Case Officer : Stuart Corbey
Reference : BR/247/18/HH

Re : 75 Mead Lane - BR/247/18/HH

computer reference Murphy.1005	project Proposed Alterations to House at 75 Mead Lane, Bognor Regis West Sussex PO22 8AP Mr and Mrs D Murphy	scale 1:100	title Plans as Proposed	job no. RBA.025	drwg no. 1005	rev
drawn by JTR		date SEP'18

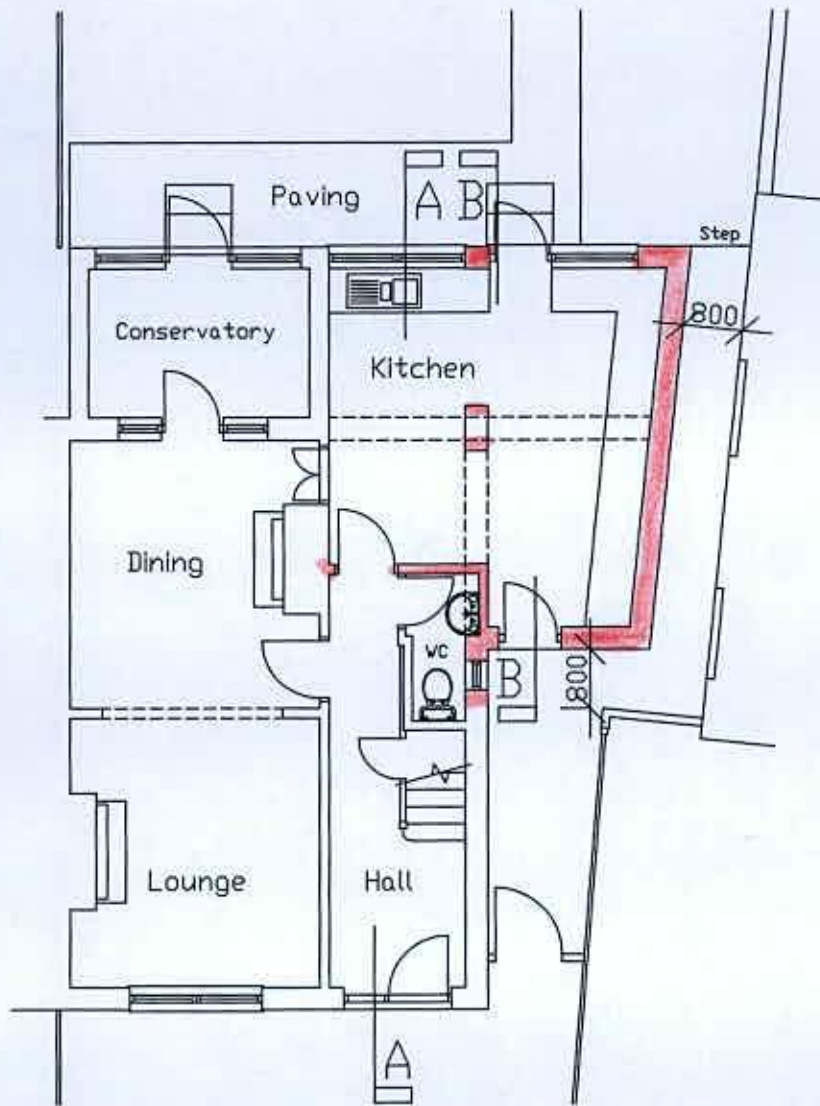
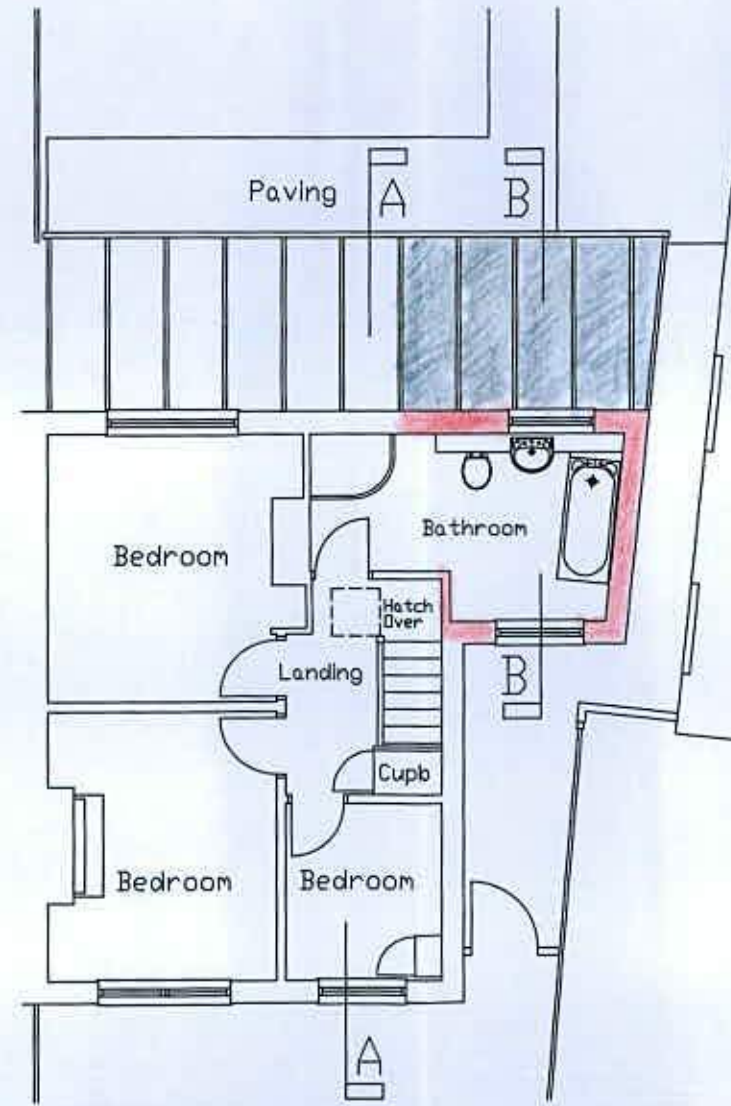
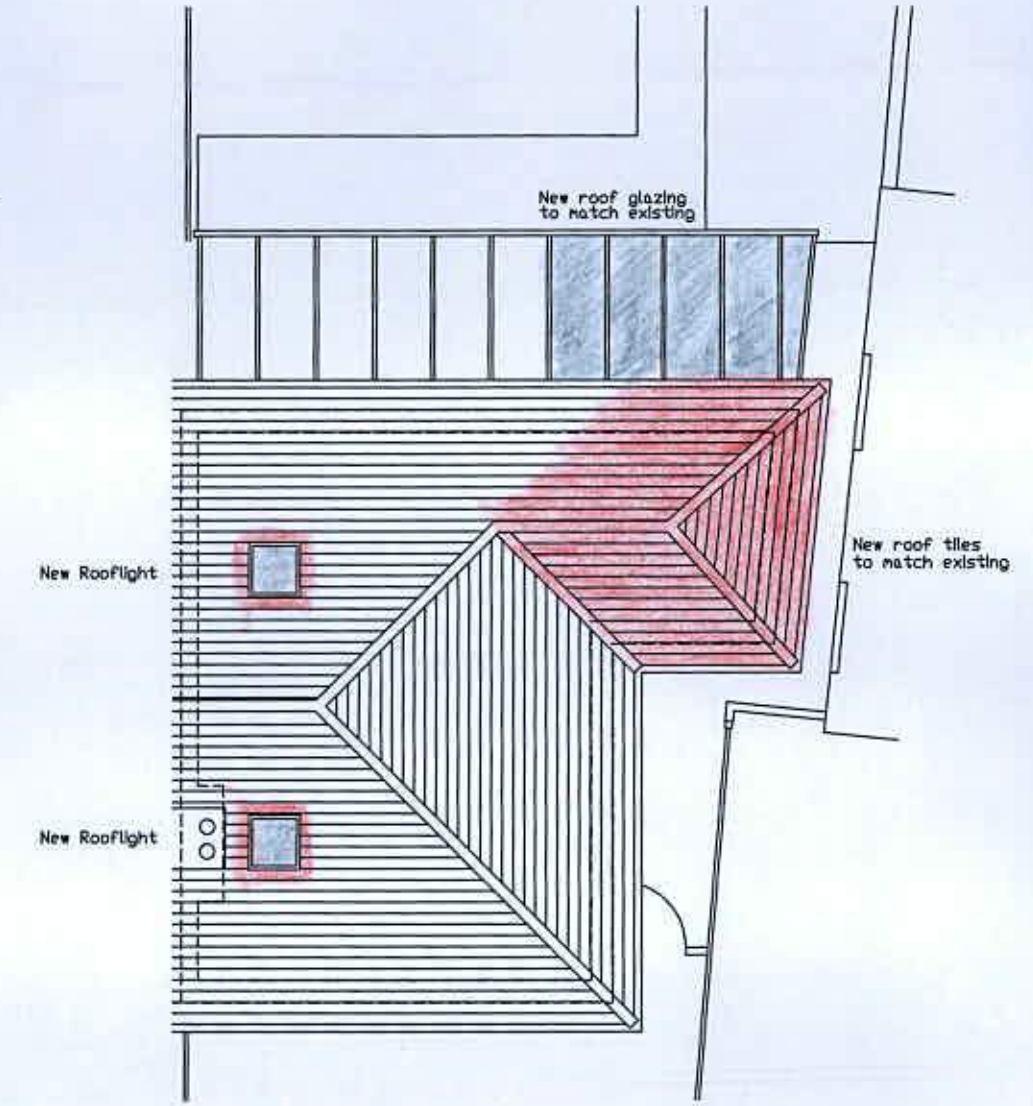
Drawings RBA.205/1005 clearly show that at ground floor level and first floor level, that the external walls are 800mm from my boundary.

The minimum distance should be 1000mm, thus providing a workable distance for / should maintenance be required.
